Development Control
Ribble Valley Borough Council

App no: 24.1014

Address: Keepers Cottage Northcote Road Langho

Proposal: Variation of Condition 1 (Approved Plans) and Condition 19 (HVAC) of previous application 3/2022/0637 as varied by application 3/2024/0245

SHEET:  
PROPOSED SITE PLAN

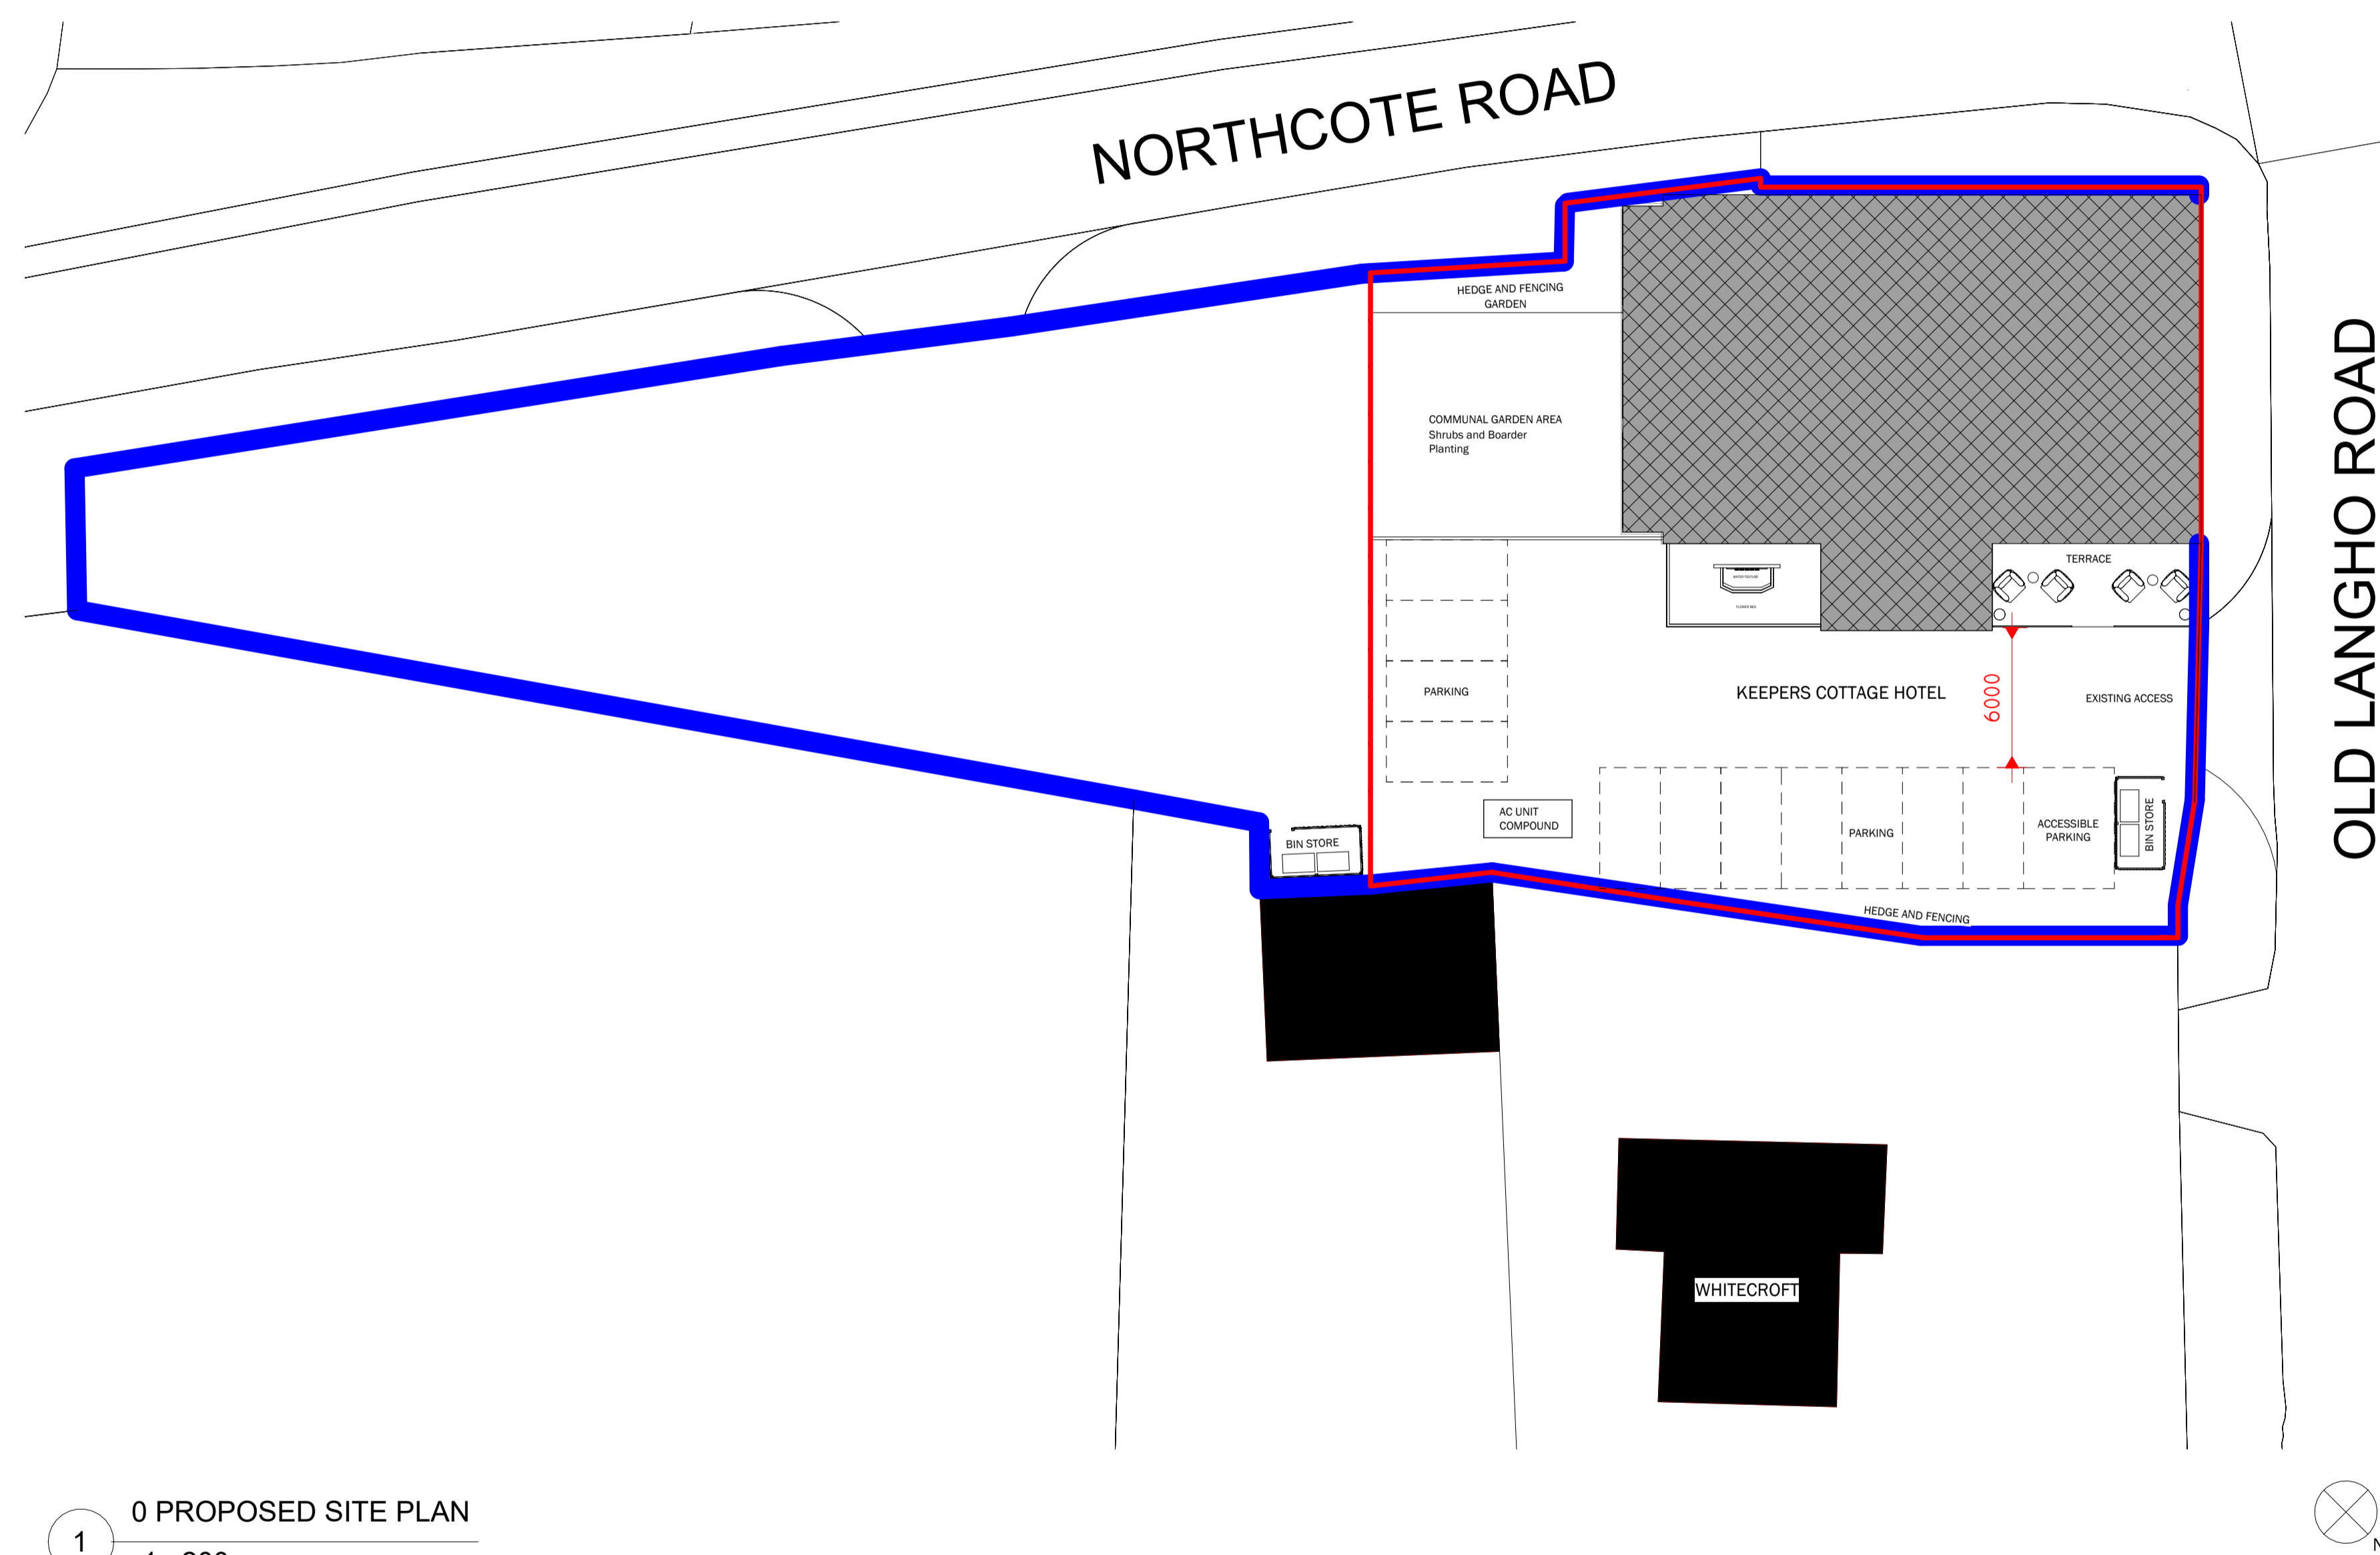
The plans are replaced with 'Proposed site plan A1.2 dated 14.01.25' with 12 car parking spaces being retained and the access arrangements remain the same.

There is no objection to the variation of plan.
